Appeal Decision

Appeal Ref: APP/R5510/W/21/3275918

Land Between 85 & 85A Larch Crescent, Hayes UB4 9EB

- The appeal is made under section 78 of the Town and Country Planning Act 1990 against a refusal to grant planning permission.
 - The appeal is made by Mr J S Hayer against the decision of the Council of the London Borough of Hillingdon.
 - The application Ref 21521/APP/2020/3641, dated 2 November 2020, was refused by notice dated 21 January 2021.
 - The development proposed is construction of single storey, one-bedroom house with associated parking, amenity space and installation of vehicular crossover to front.
-

Proposed front elevation
No. 85

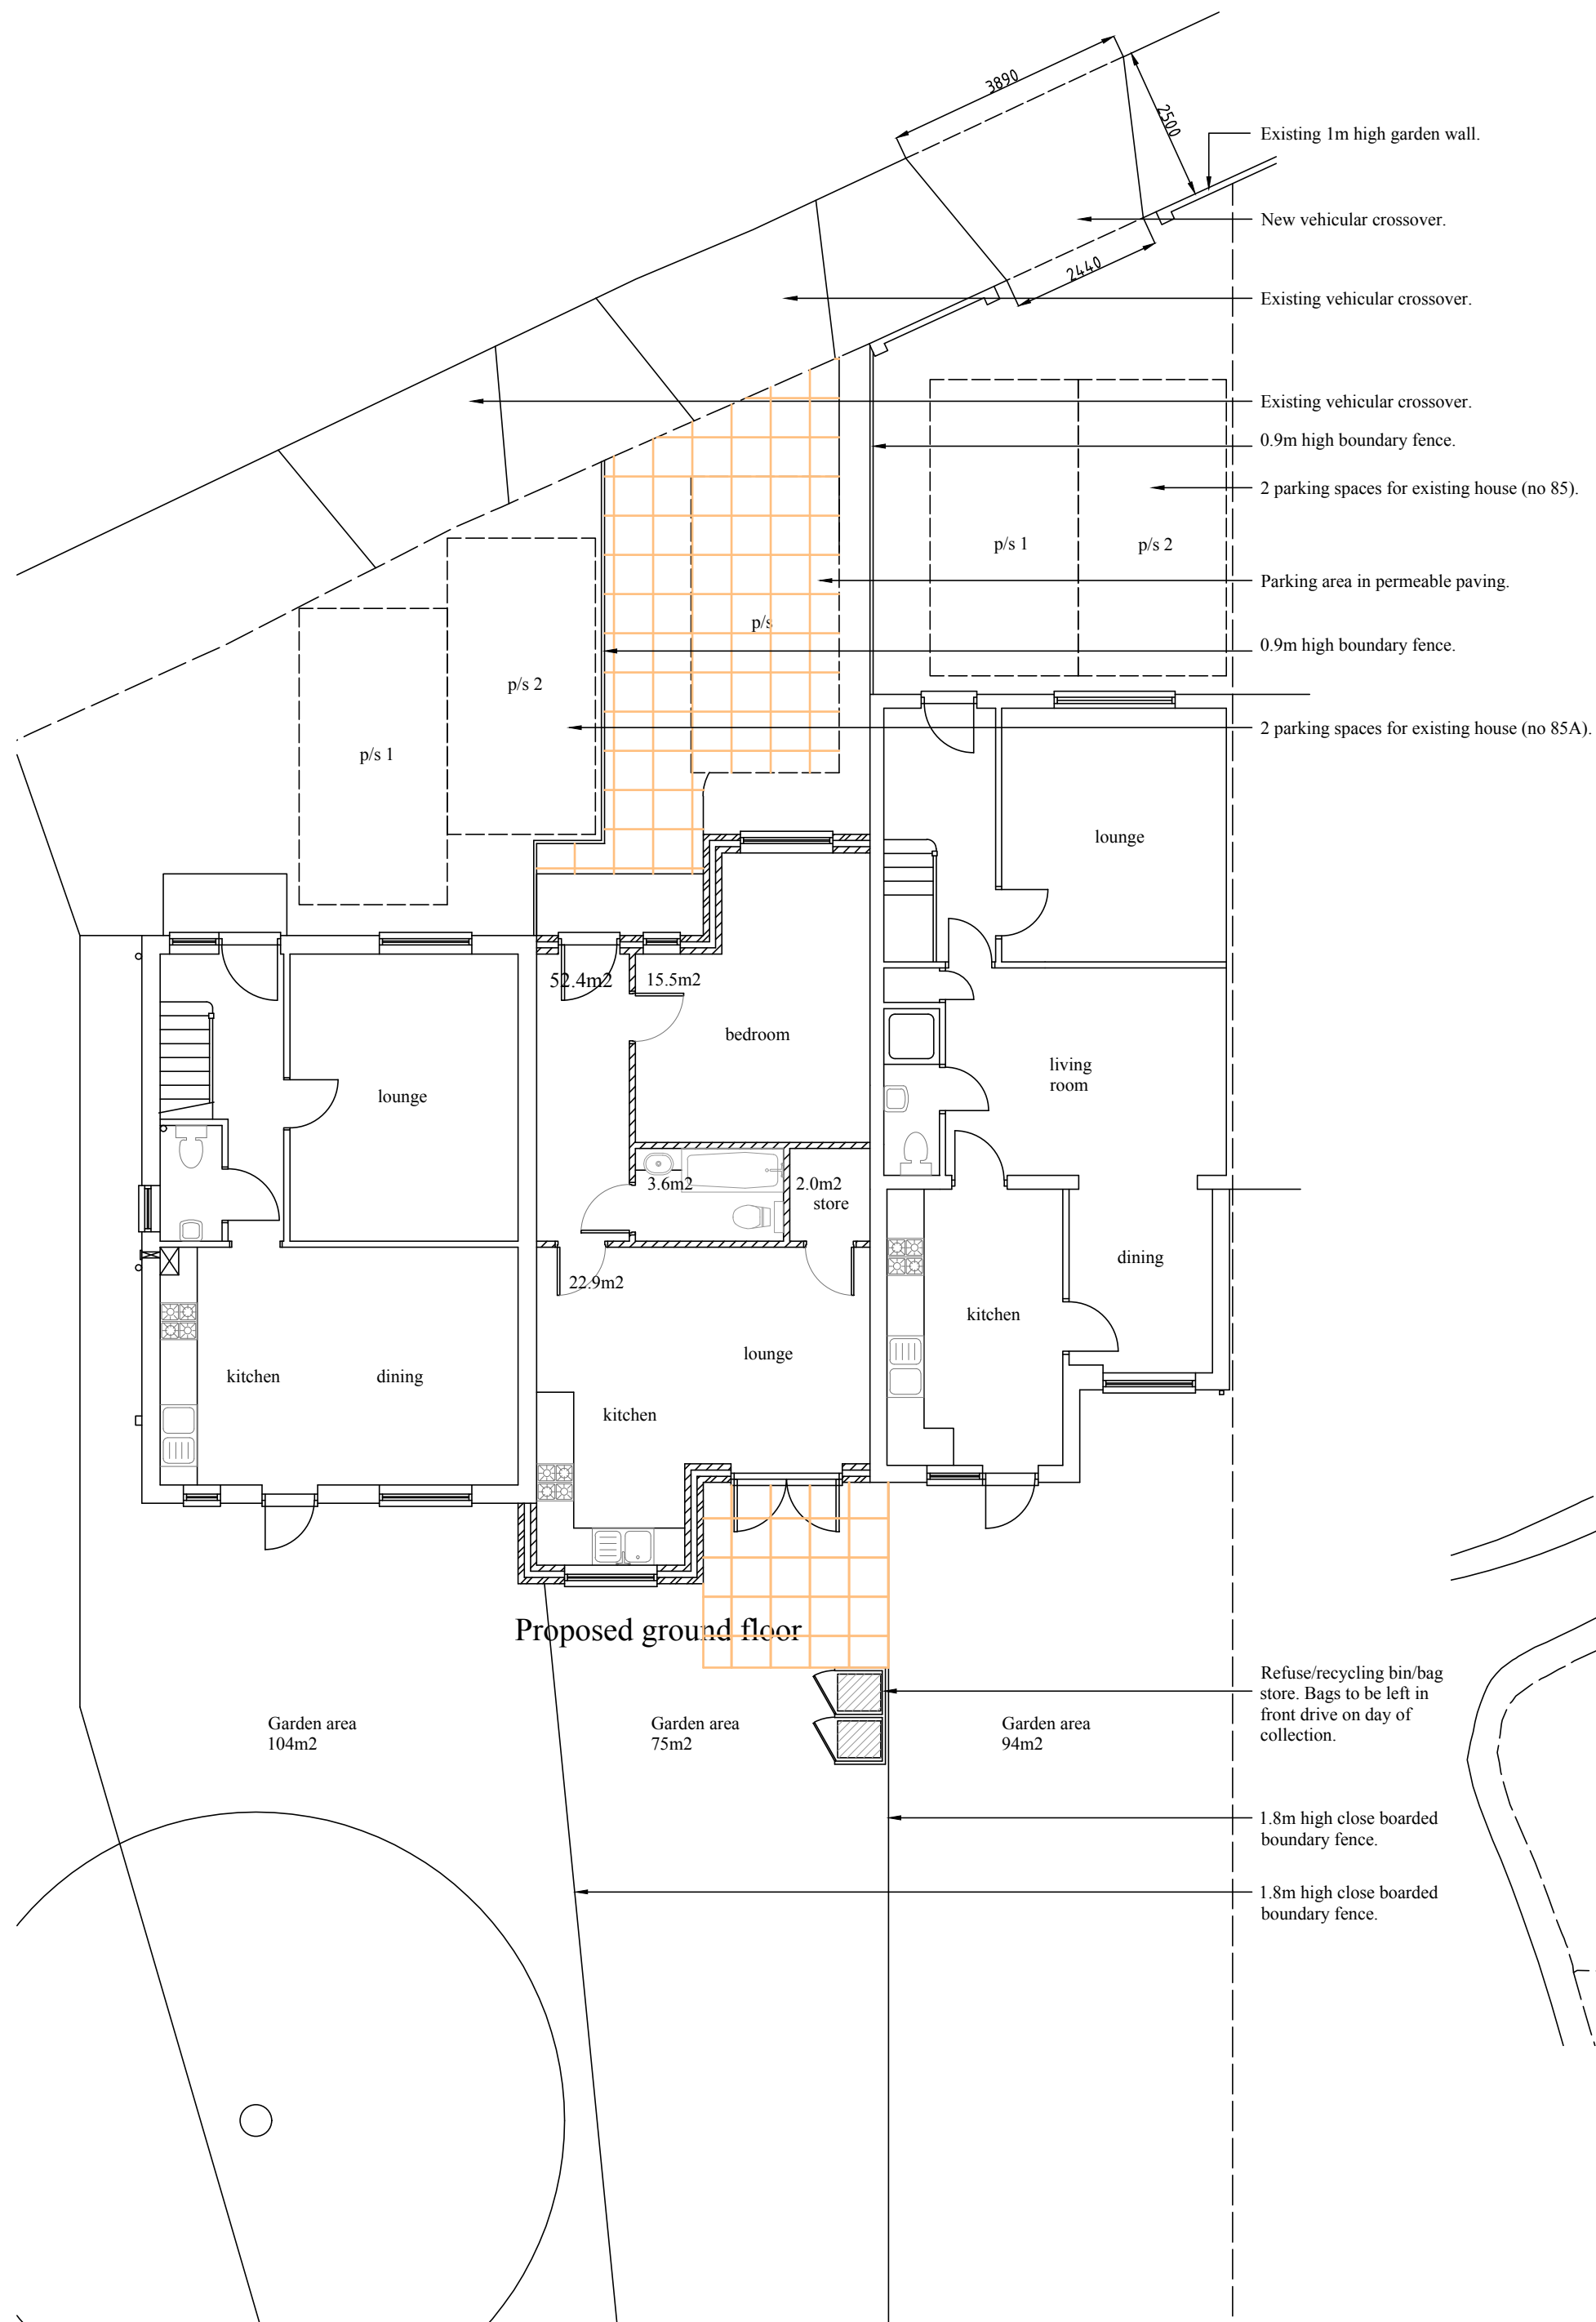
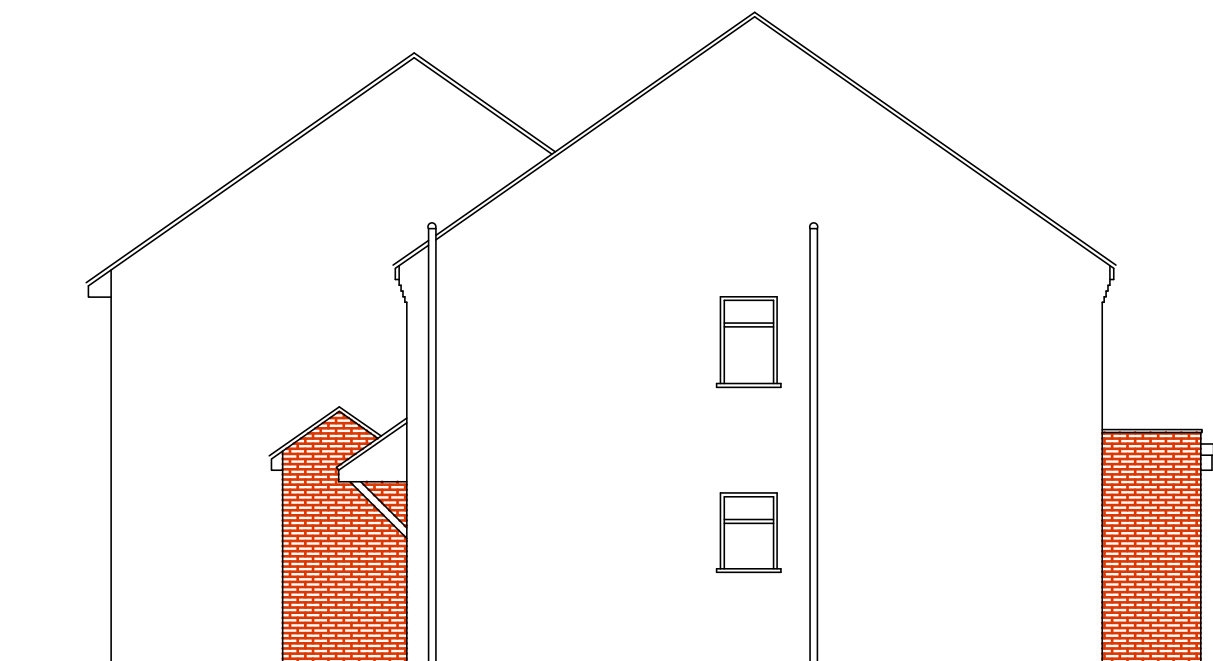
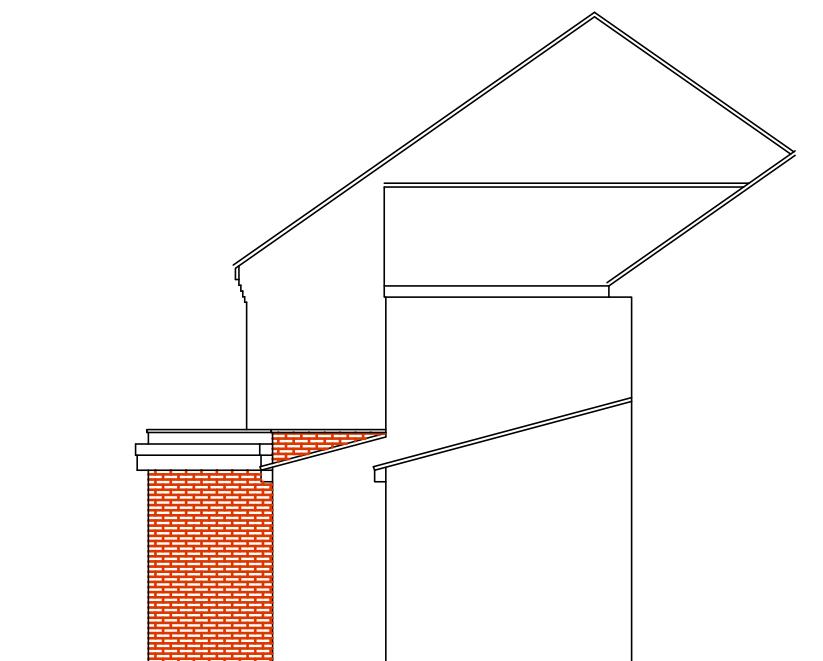
5. The proposed new dwelling would occupy the existing built form of the extensions with the front elevation having two windows and a door. In contrast to the design of the approved garages, the resulting single storey bungalow style dwelling, located between the neighbouring properties with a markedly different two storey scale and character, would appear awkward and incongruous. It would also lead to the wider row of properties having a disjointed appearance, and this would be emphasised by the dwelling's stepped front elevation appearing as an anomaly within the group. Moreover, a portion of one of No 85A's parking spaces and the adjoining section of the boundary fence would occupy a substantial part of the area located between the front door and the back edge of the pavement. Consequently, the new dwelling would have an unduly cramped appearance in the street scene.

6. The appellant notes there are bungalows sited across the road from the appeal site. However, the terrace of bungalows read as a cohesive group of properties. They also have fairly substantial dual pitched roofs, in stark contrast to the proposed dwelling which would have a low false pitched roof to the front and a flat roof behind. Accordingly, the presence of the bungalows within the same street scene does not justify the scheme.

Site Plan
1:500

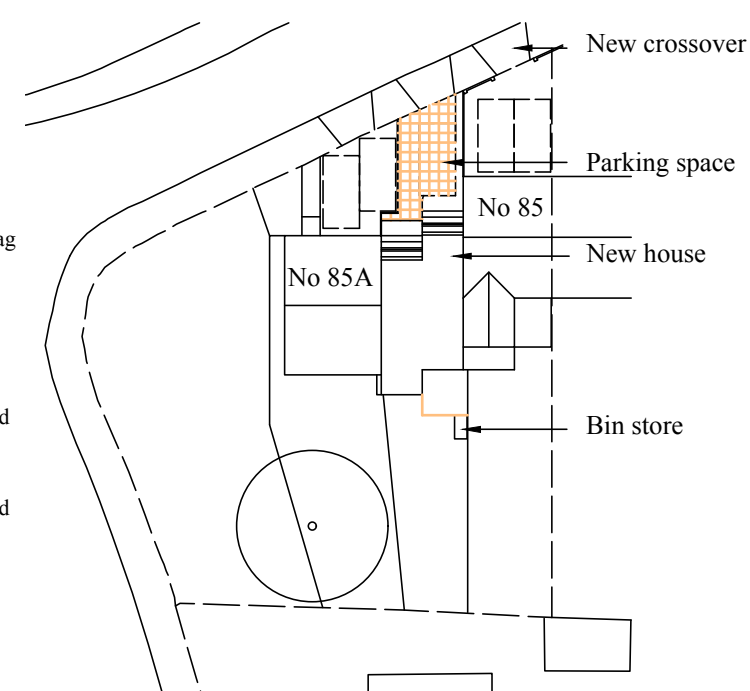
8. While the Council has expressed concern in terms of accessing the proposed parking spaces with the crossover arrangement shown in the submitted plans, it has not sought to clarify the precise nature of the deficiency in this regard. The crossovers that would serve No 85A and the proposed dwelling already exist and they would appear to enable suitable access to the respective parking spaces. What is shown as an existing 1m high front garden wall on the submitted plans at No 85 could have acted as a constraint to accessing one of the parking spaces from the proposed new crossover for that property. However, the relevant section of wall has since been removed.

9. Consequently, as the proposed crossover arrangement would enable the parking spaces to be accessed, the development would not have a harmful effect on public and highway safety. As such, it would comply with Policies DMT 2 and DMT 6 of the DMP. Amongst other things, these policies seek to ensure development does not contribute to a deterioration of safety for road users and residents, and that parking standards are complied with.
